RE: Griffith Mercer Island House Deck Remodel  
2443 84<sup>th</sup> Ave SE  
Mercer Island, WA 98040  
**Permit Number: 1906-185**  
**SUB5-PLANS REVIEW RESPONSE**

The following are “Jackson Main Architecture” (JMA) responses to the plan review comments raised in the “**SUB-5 Plans Review**” plan review document, updated on the portal on August 19<sup>th</sup> and September 8<sup>th</sup>, 2020. Responses to the review comments are numbered to correspond to the appropriate number in the review comments for the project referenced above.

A0.01

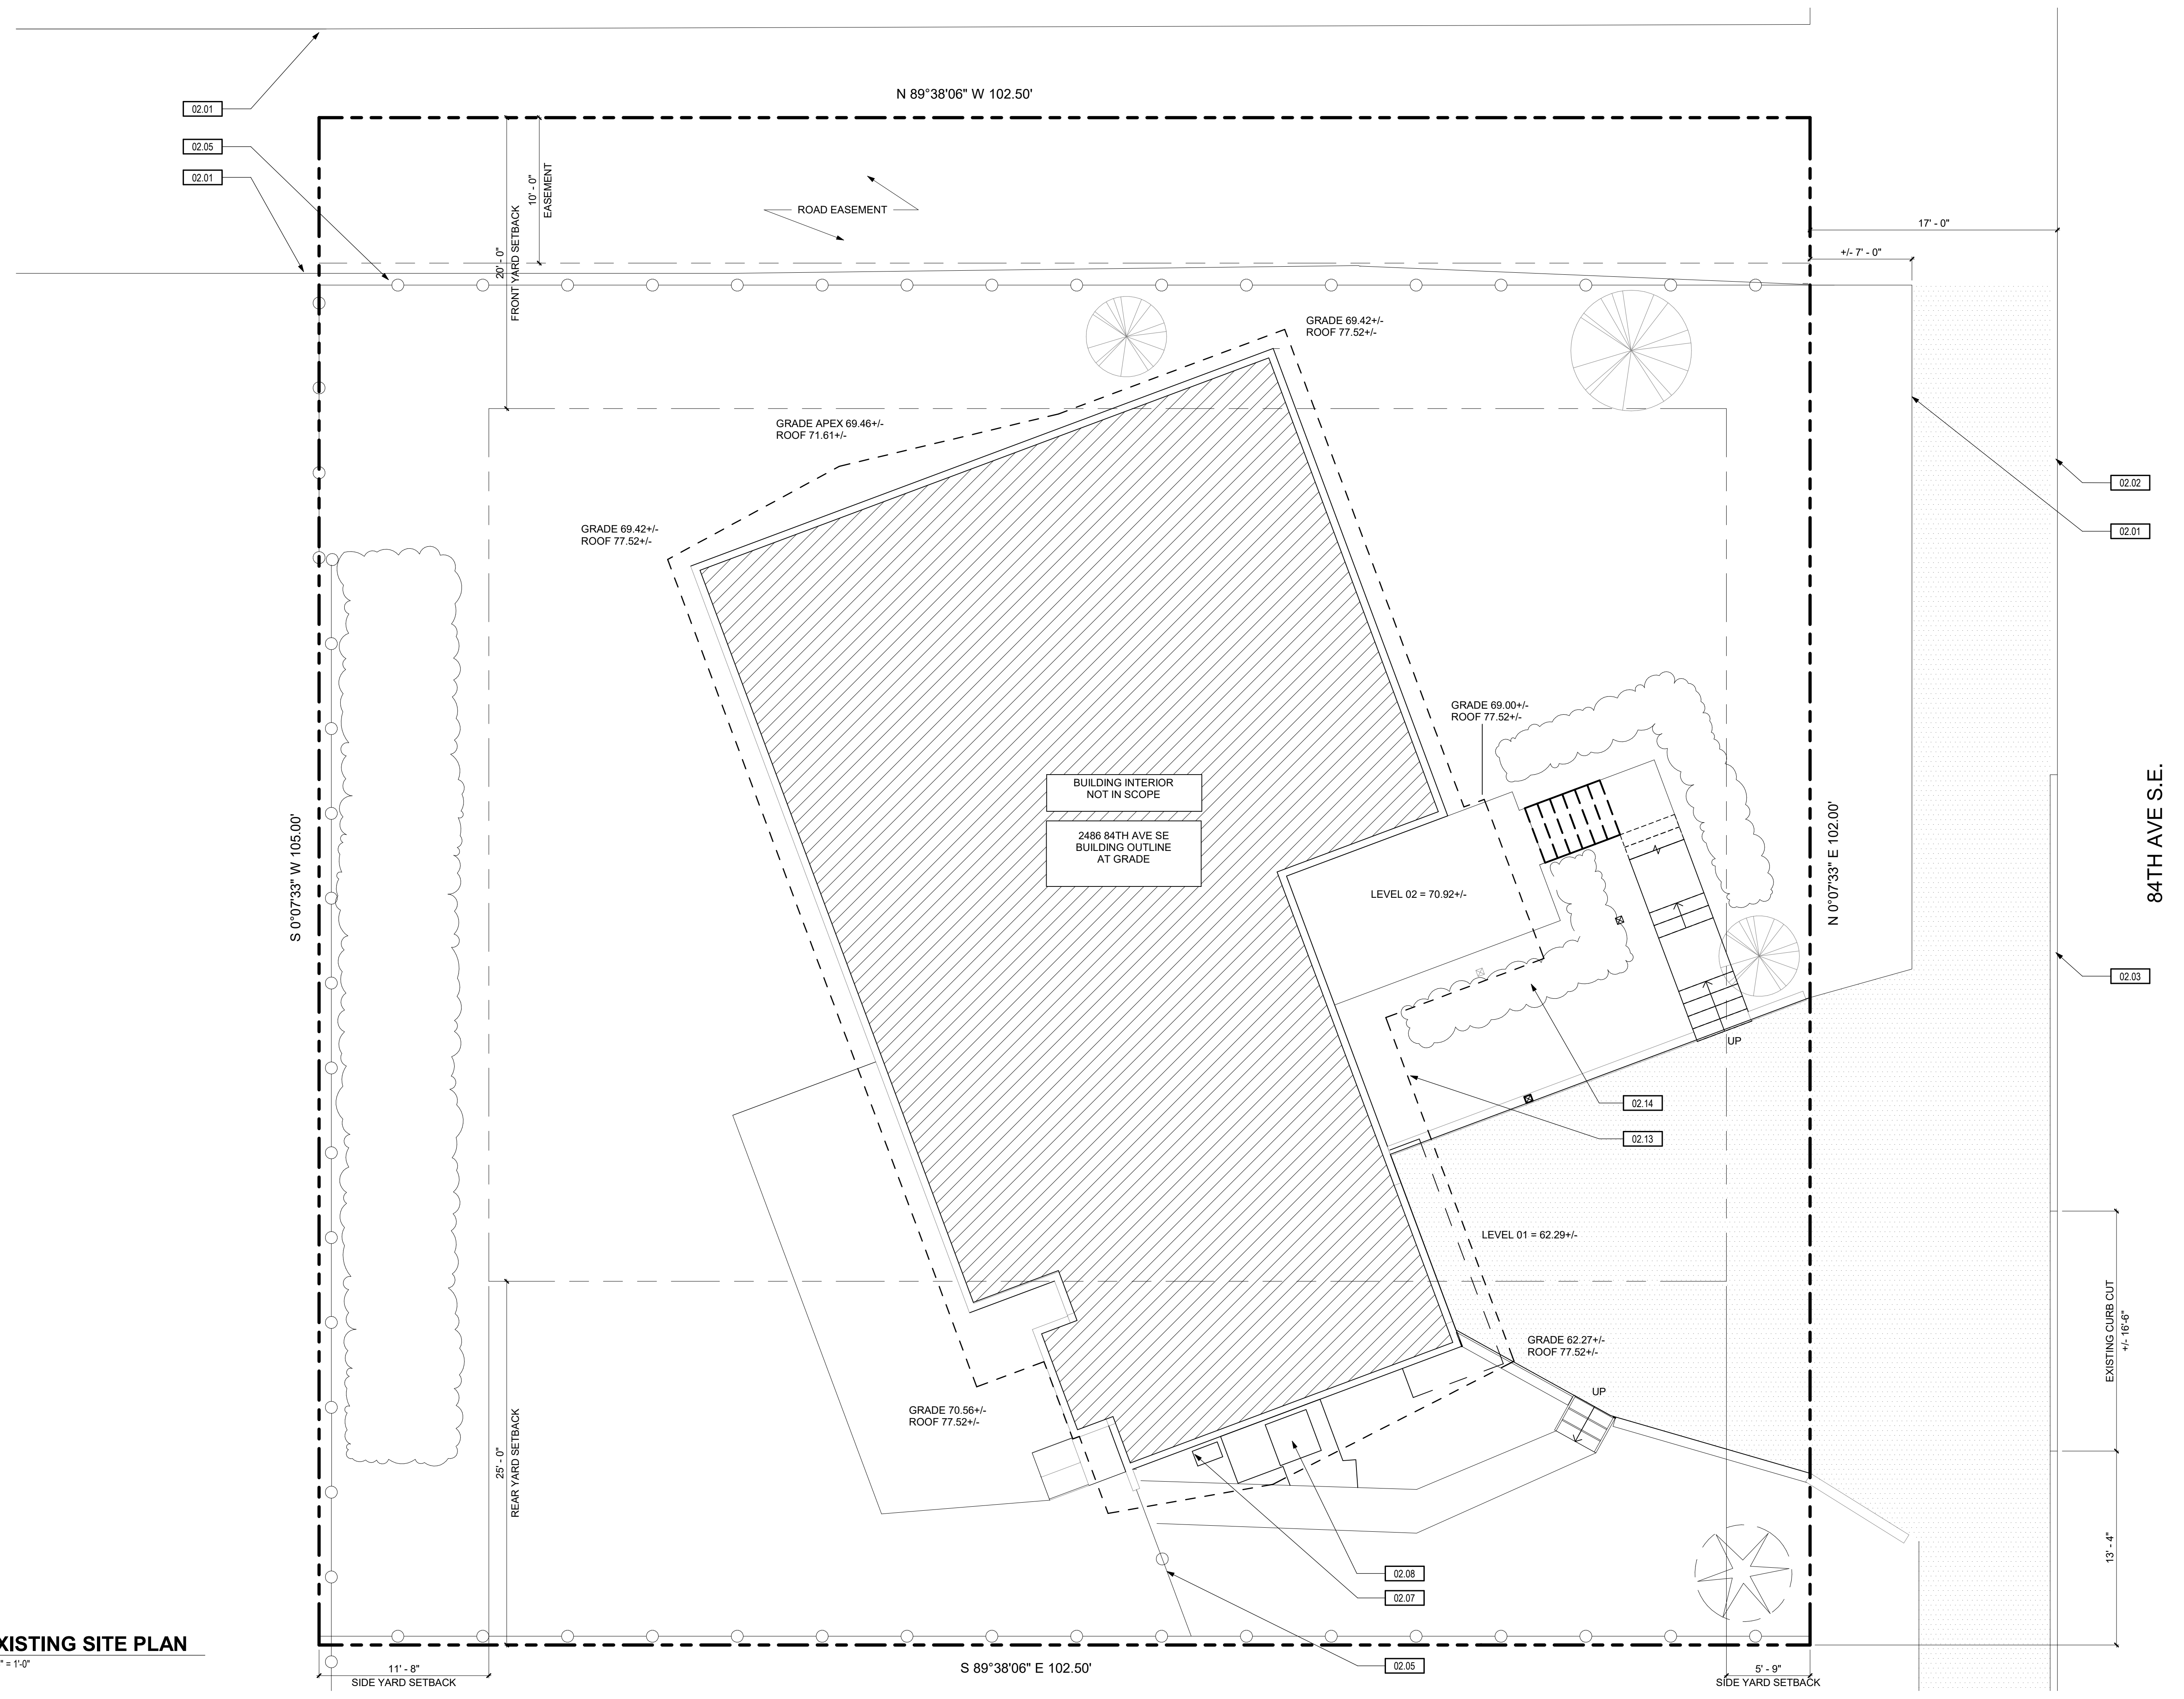
*Please provide a site plan, drawn to scale, showing the proposed conditions of the lot. The site plan needs to show the entire lot, as well as all proposed lot coverage. (9/8/2020 Andrew Leon)*

**Jackson Main – Sara Vernia (JMA3): A site plan, drawn to scale, showing proposed conditions of the lot has been added to the set. Sheet A0.01 has been modified to only show the existing site conditions. Sheet A0.02 has been added to show the entire lot as well as all proposed lot coverage and site diagrams.**

A2.02

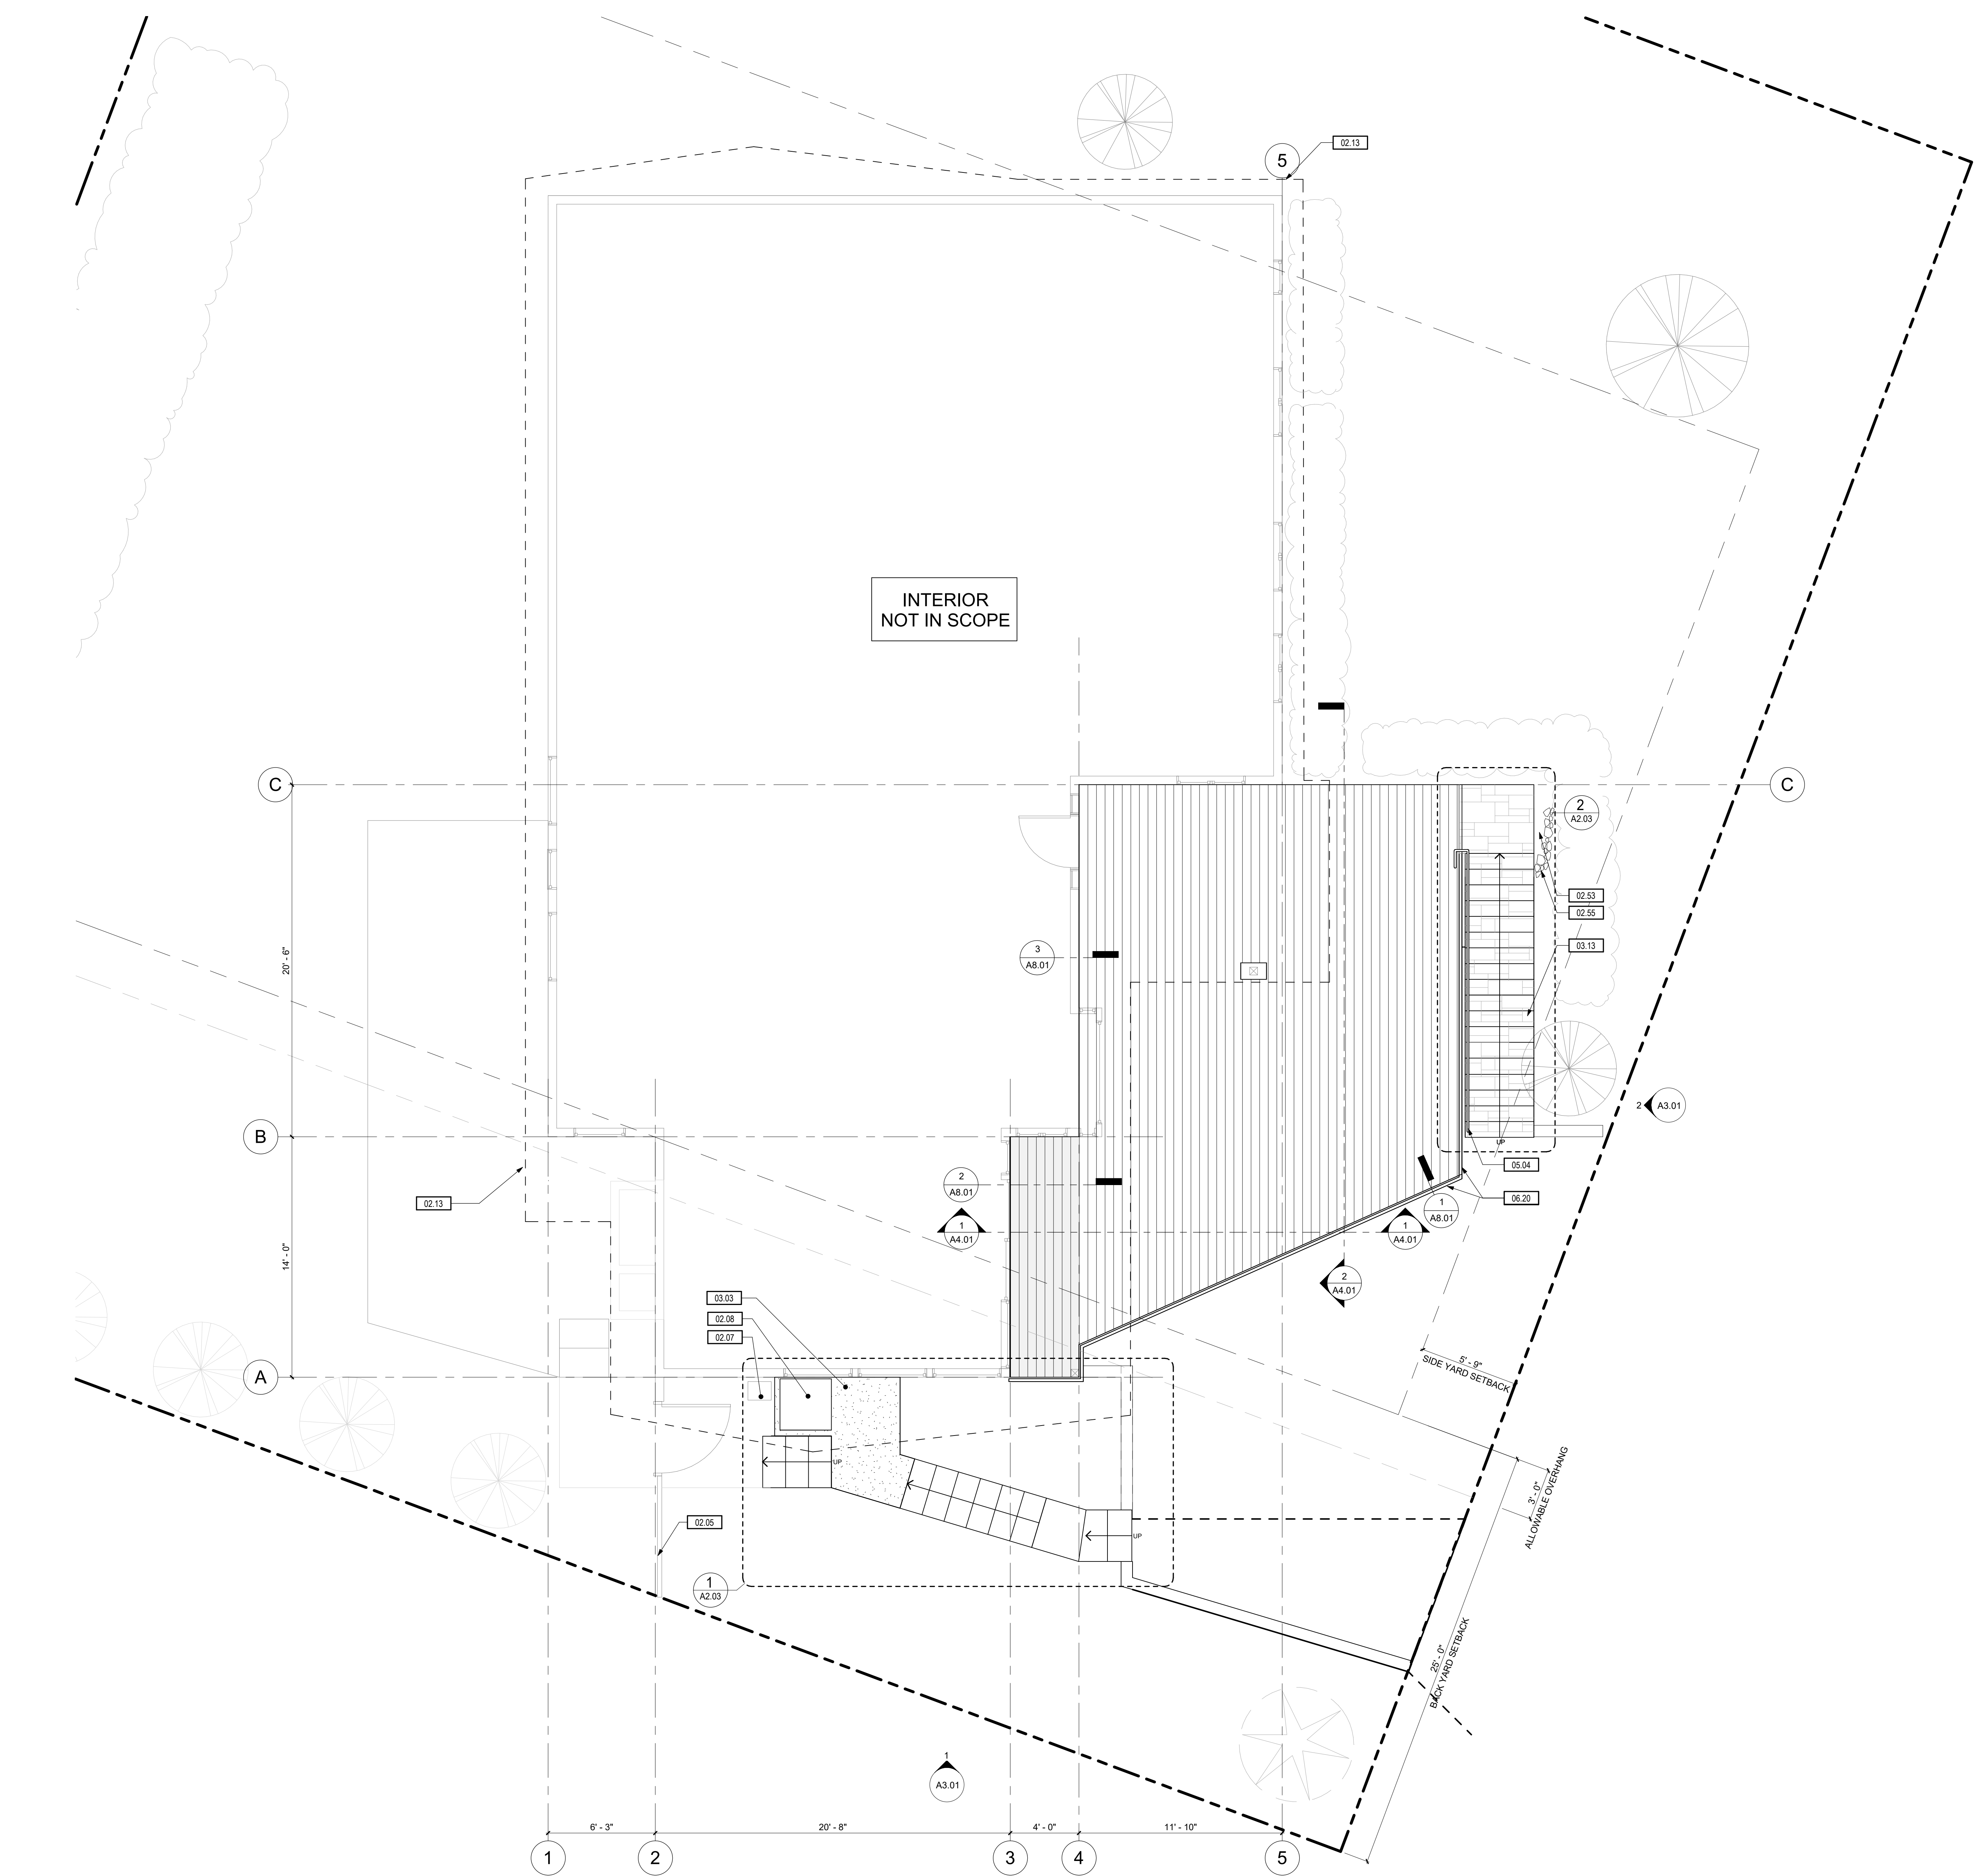
3. *Page 6 (A2.02)*  
*Retaining walls setbacks are limited to 6 feet in height for fill slopes and 12 feet in height for cut slopes. Please provide the maximum height of this retaining wall. (9/9/2020 Andrew Leon)*

**Jackson Main – Sara Vernia (JMA3):** The retaining wall that was tagged in the correction document is existing to remain with new bluestone thin-set tile cladding. None of the retaining walls that are existing or proposed exceed 6 feet in height from the finish grade. Please see sheets A2.01, A3.01 and A4.01 for added notations for maximum retaining wall heights.

2 EAST ELEVATION
1/4" = 1'-0"

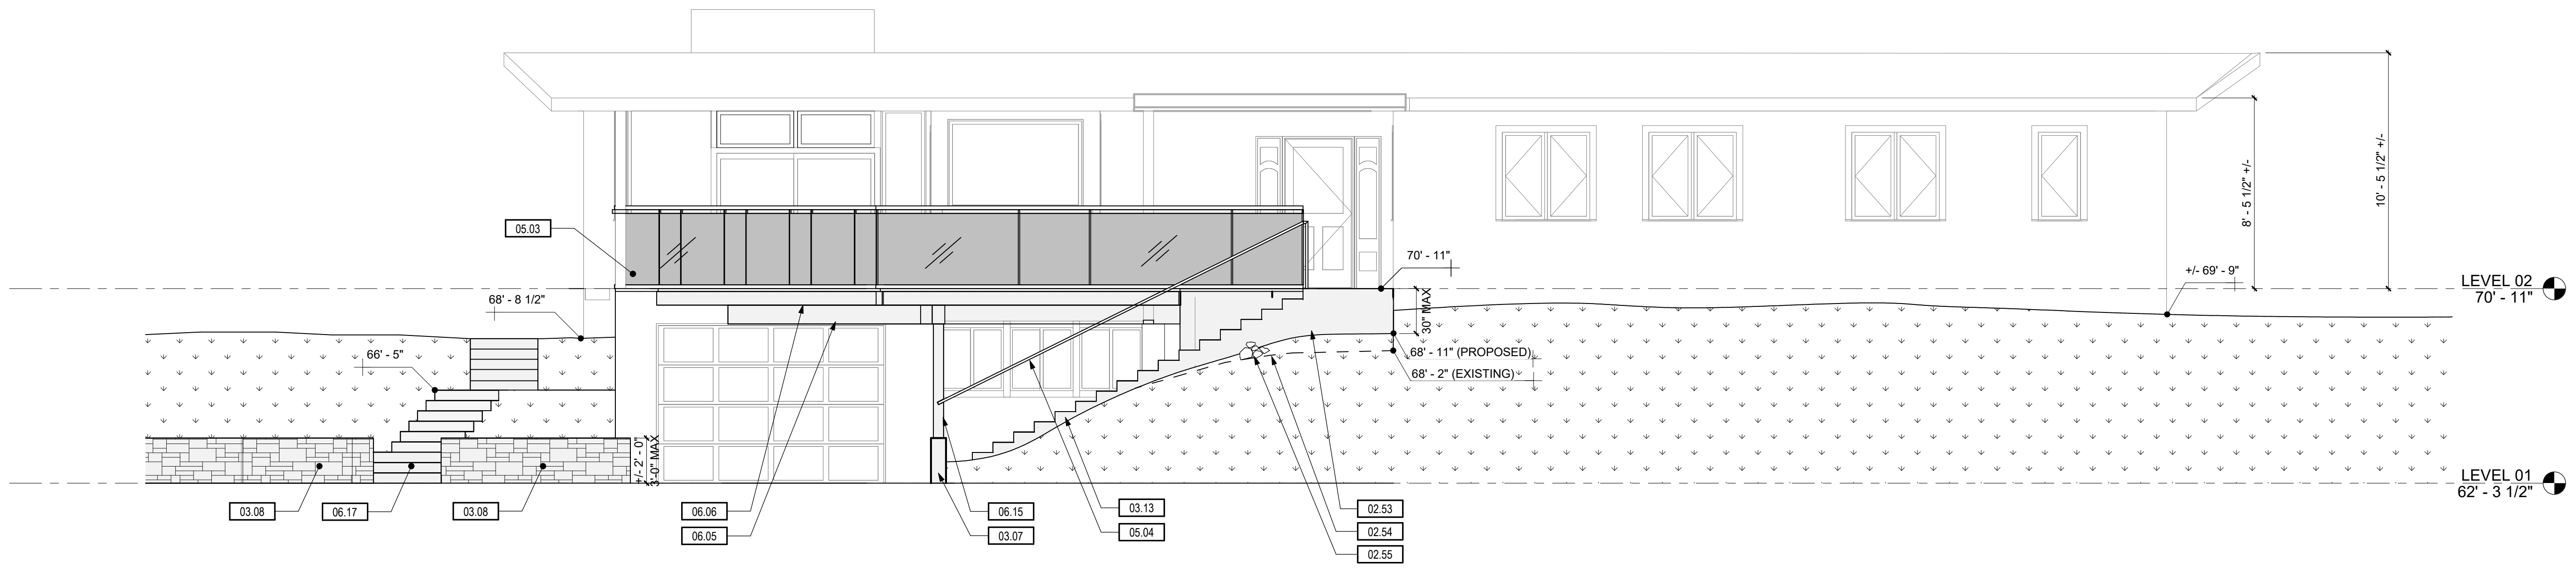
4. *Page 8 (A3.01)*  
*Please show and label the existing and finished grade on the elevations. (9/9/2020 Andrew Leon)*

A note was added in the general sheet notes to read “All existing and proposed finished grade elevations are to considered equal unless noted otherwise”. Areas where the proposed finished grade differs from the existing is now shown on elevation 2/A3.01 and keynotes 2.53 and 2.54 have been added for clarification.
